Our ref: 21SYD_19423

Response to Submissions – Wee Waa High School BDAR

Please find attached advice to assist the proponent (Schools Infrastructure NSW) in providing a Response to Submissions on the Wee Waa School project. Responses were prepared by the author of the BDAR - Phoebe Smith (BAM Accredited BAAS21011).

Figure 5: Targeted surveys

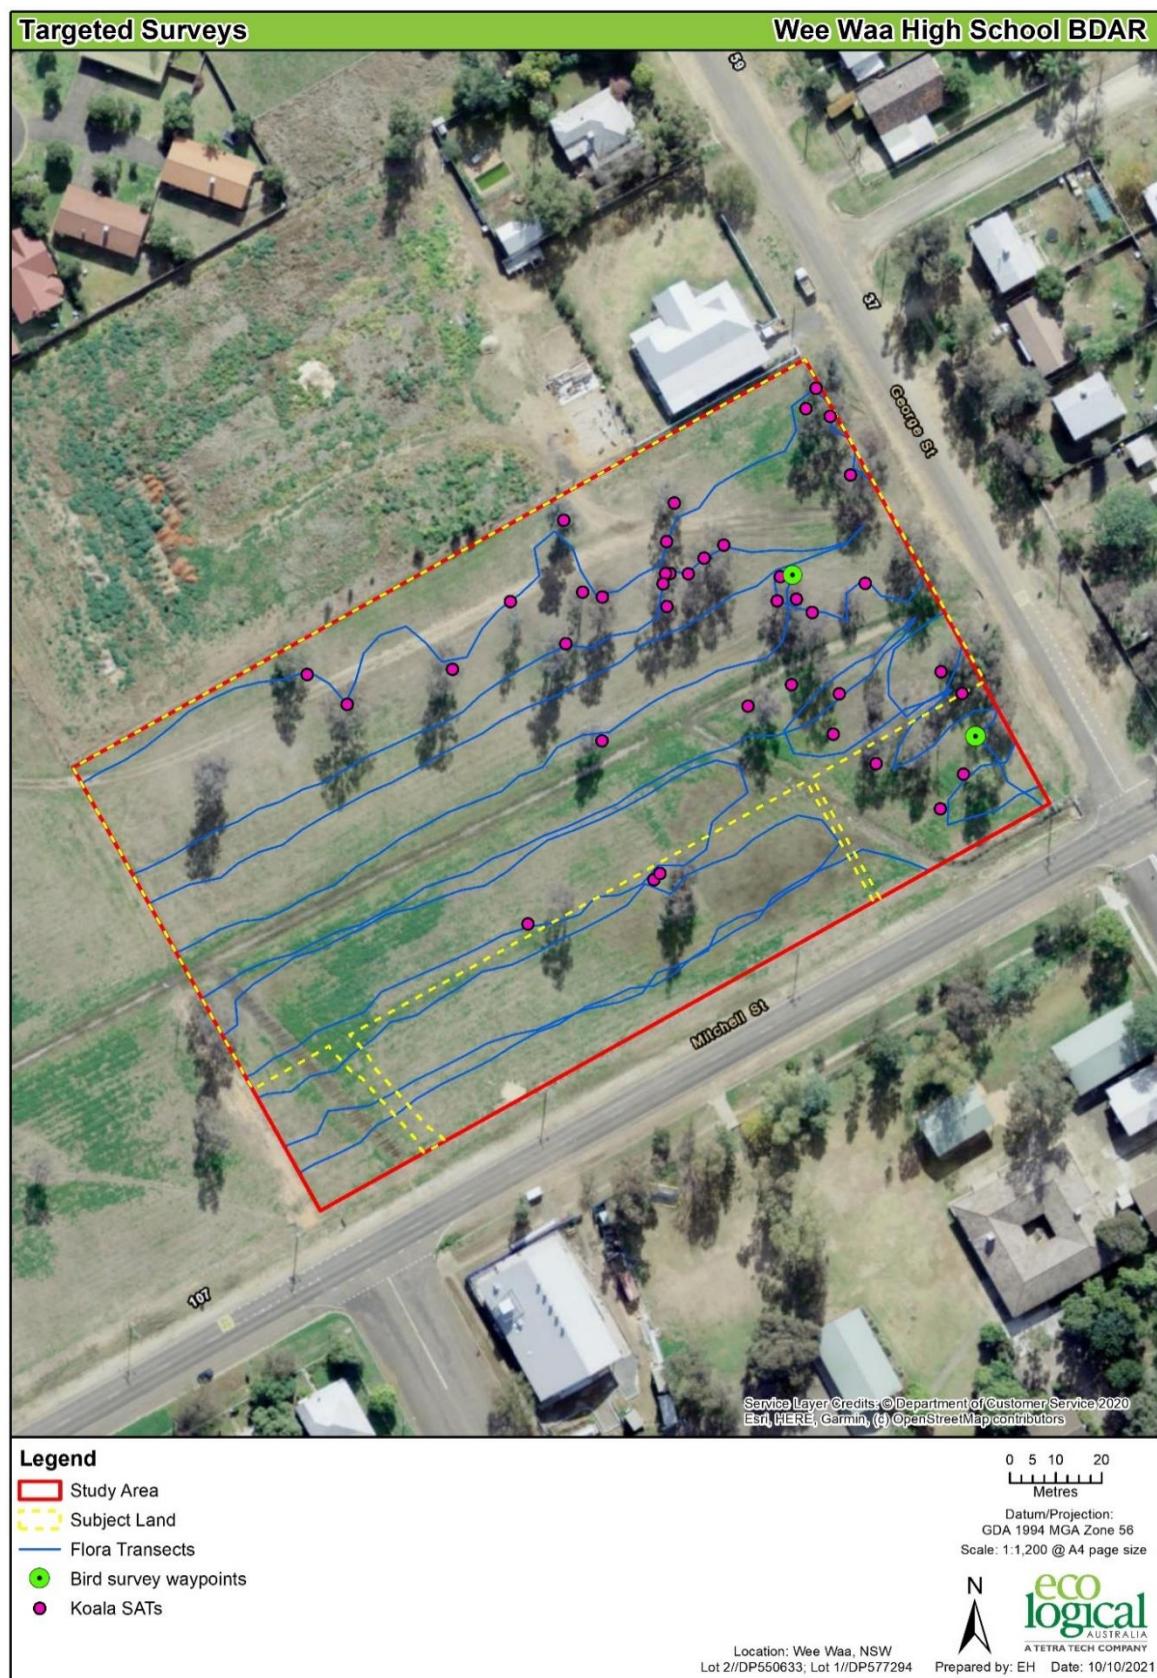
51 Exclusion of the bush stone-curlew and shrub sida from consideration as species credit species requires further justification

Conclusions regarding which candidate species credit species require further assessment are presented in Table 11 of the BDAR (from page 23). When assessing which candidate species credit species may be excluded from further consideration, BAM subsection 5.2.3 (Step 3) stipulates that the BDAR must include: a description of microhabitats required by the species, supported by evidence such as published literature. details of the field assessment conducted to determine if habitat constraints or known microhabitat(s) are absent, or if present, whether it is degraded to the point that the species is unlikely to use the subject area. Describing a vegetation zone as degraded or low/poor condition is not adequate justification to remove a candidate species credit species from the generated list. Evidence must support all conclusions. Species credit species excluded based on habitat constraints (as listed in the TBDC) being absent or degraded Justification for excluding the bush stone-curlew (*Burhinus grallarius*) from further assessment is currently inadequate. Fallen/standing dead timber, including logs, is identified in the TBDC as a habitat constraint for the bush stone-curlew. The BDAR indicates that fallen timber was recorded on the site, but states that the amount of fallen timber present is not adequate for this species. BCS advises that this species may persist in such town spaces with minimal fallen timber. Additional justification based on site specific factors and threats present, supported by published literature, would be required to exclude this species under BAM subsection 5.2.3. Species credit species excluded based on known microhabitats being absent or degraded When excluding three fauna and two flora species credit species based on microhabitats being absent, or degraded to the point where the species is unlikely to use the site, the BDAR: does not include a sufficient description of microhabitats required by the subject species, supported by published literature. In most cases, partial information from the DPIE website only is quoted as justification for exclusion of these species. This approach is inadequate; does not clearly relate the results of field assessment to conclusions on the presence (and level of degradation) or absence of the microhabitats required by these species. The five candidate species credit species excluded based on the above factors have been discussed with the relevant BCS Ecosystems and Threatened Species staff. BCS agrees with the exclusion of four of those species, albeit for alternative reasons to those presented in the BDAR in most cases. However, justification for excluding shrub sida (*Sida rohlena*) from further assessment remains inadequate. The BDAR excluded shrub sida from further consideration because 'This species grows on flood- out areas, creek banks and at the base of rocky hills, which are not a habitat feature of the subject land'. The BDAR indicates that the site has cracking clay soils. The BDAR does not recognise that shrub sida has been recorded on grey clay. Based on the information presented in the BDAR, together with aerial images of the site, BCS considers the south eastern portion of the development site within the zone 'PCT 40 Moderate' to be potential habitat for this species.

BDAR updated. Bush Stone-curlew and Shrub sida have been included as a Candidate species in Table 11. BDAR has been updated to more accurately describe survey effort for these species (see Tables 12 and 14 and Figure 5). Nocturnal surveys were undertaken for the original footprint (owl surveys), however these were not required once new footprint was delivered. Spotlighting was conducted over both nights (30/09/21 and 1/10/21) and no individuals of Bush-stone Curlew were recorded (sighted or heard). All threatened flora produced by the BAM-C was surveyed for during the targeted flora surveys. Neither Bush Stone-curlew or Shrub sida were recorded. See Table 11 of the BDAR and Table 12 targeted surveys.
